Subject: FW: 6 Chichester Rd DOC - FURTHER EXTENSION OF TIME - 27/4

Subject: RE: 6 Chichester Rd DOC - FURTHER EXTENSION OF TIME

From: Amy Myer <Amy.Myer@arun.gov.uk>
Sent: 20 February 2020 15:11
To: Anna Harper [REDACTED]
Subject: [EXTERNAL] 6 Chichester Rd DOC - EV charging points

DRAWING TITLE
SITE LAYOUT - PHASE 4c

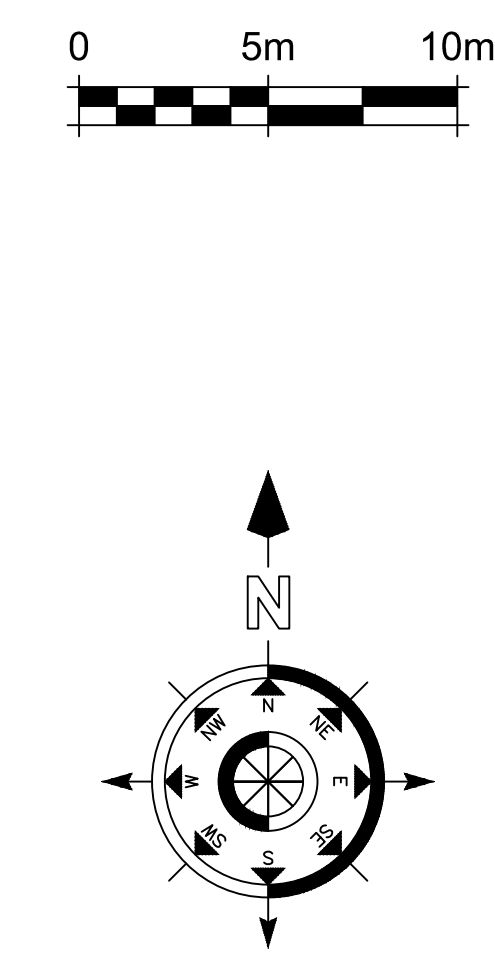
Apparently, the previous EH Officer for the other DOC app (BE/122/19/DOC) did not raise an objection. However, the current EH Officer (and their Manager is in agreement) is not satisfied that the 'garage-only' strategy meets the requirements of the policy or condition. I appreciate there was an inconsistency in approach there, and the EH team are discussing this. Notwithstanding this, I must follow the advice of our EH team on this matter.

They are not suggesting we refuse the current DOC app (BE/17/20/DOC) but simply seek further clarification regarding the required ratios as per my earlier email. As such, to avoid delay please can you provide this revised plan to satisfy the requirements?

I don't think we can recommend discharge just yet. From the submitted plan, I can't tell whether the required ratios have been met so please may the applicant provide a more detailed plan which clearly demonstrates that 100% of houses with garages or driveways will each have an electric vehicle charging point and residents of flats and/or apartments will have access to a shared charging point (as per the percentage stated in the ADC Parking Standards document).

If each individual unit has the appropriate infrastructure in place to allow for an EV point to be retro-fitted, this Department would consider this an acceptable provision.

There are 7 no. units approved under this application, 3 of which have garages and 3 of which have car barns. Would your Environmental Health Team consider it acceptable if the charging unit was offered as an optional add on to all future purchasers on all units?

DRAWING TITLE
SITE LAYOUT - PHASE 4c

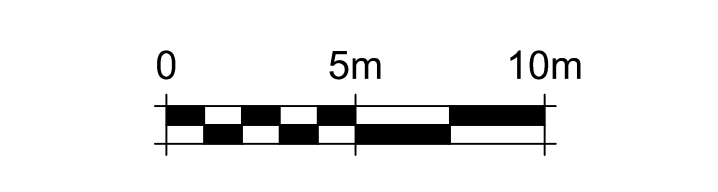
Further to Kate's email and advice I will need an updated EV plan please.
